Coolmore Australia & Darley
Australia
Drayton South Coal Project
Peer Review of Acoustic & Blasting
Impacts

Report 03

Final | 12 October 2015

Job number 243820-00

Figure 16: Noise Contours Southern Receivers – Worst Case Contour All Modelled Years

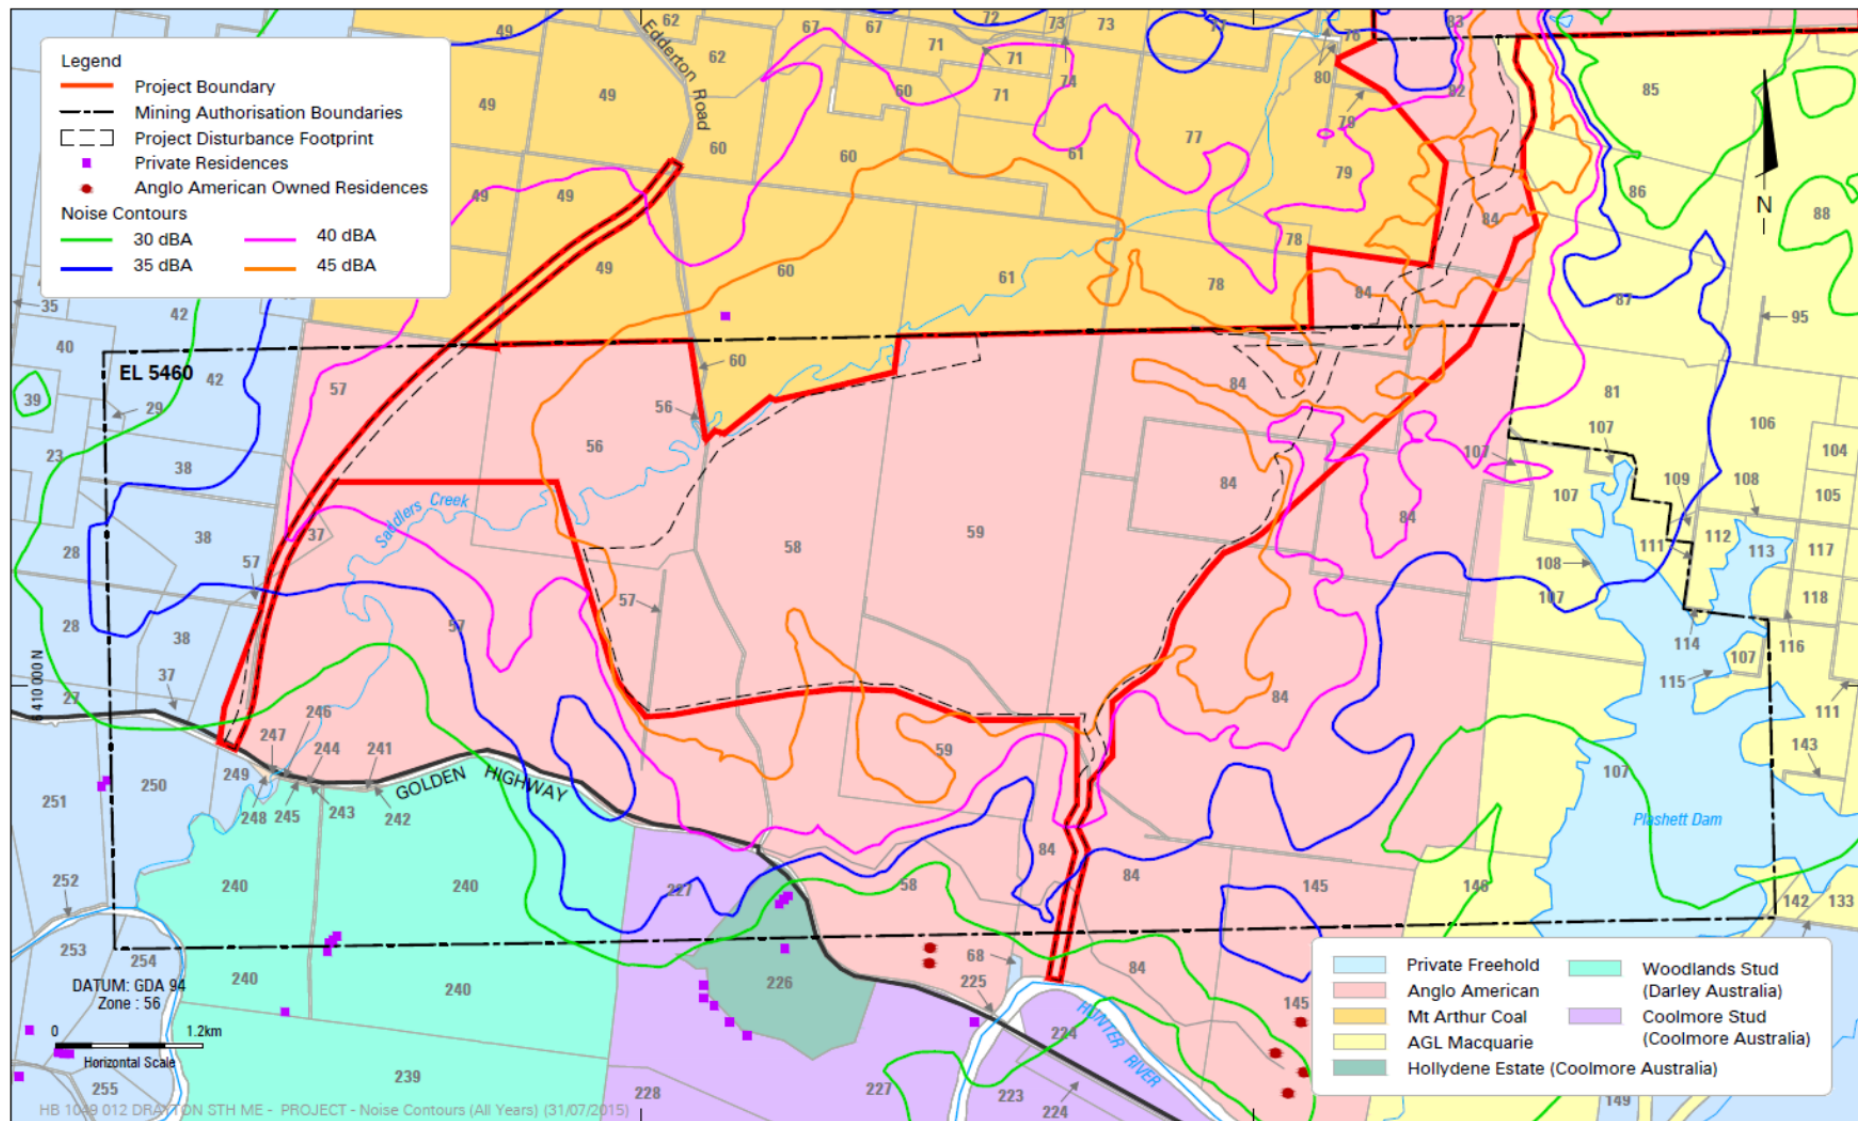
This paragraph details that noise levels will exceed the project noise limits by 2 – 5 dB(A). Should this project proceed then Anglo American will be granted permission to exceed the noise limits prescribed by the NSW INP. In our opinion it is fundamental that compliance with the noise limits is achieved and demonstrated at the EIS phase.

Bridges Acoustics provides no evidence that the proposed project will continuously comply with the project noise limits. Bridges Acoustics suggests that machinery and equipment will be attenuated, however the EIS presents non-compliance against the INP. There are no attempts to mitigate noise emitted from the proposed development to comply with the INP noise limits.

Community expectations rely on the EIS at the Development Application stage to demonstrate compliance with the project noise limits. The EIS presents non-compliance with the INP even when the noise mitigation and attenuation measures are applied.

RISK ASSESSMENT: It is fundamental at EIS stage that noise emissions from industry demonstrate compliance with the project noise limits. This assessment does not clearly define “worst case” assessments. Hence, there is a high risk that noise emitted from the mine may continuously exceed the INP noise limits.
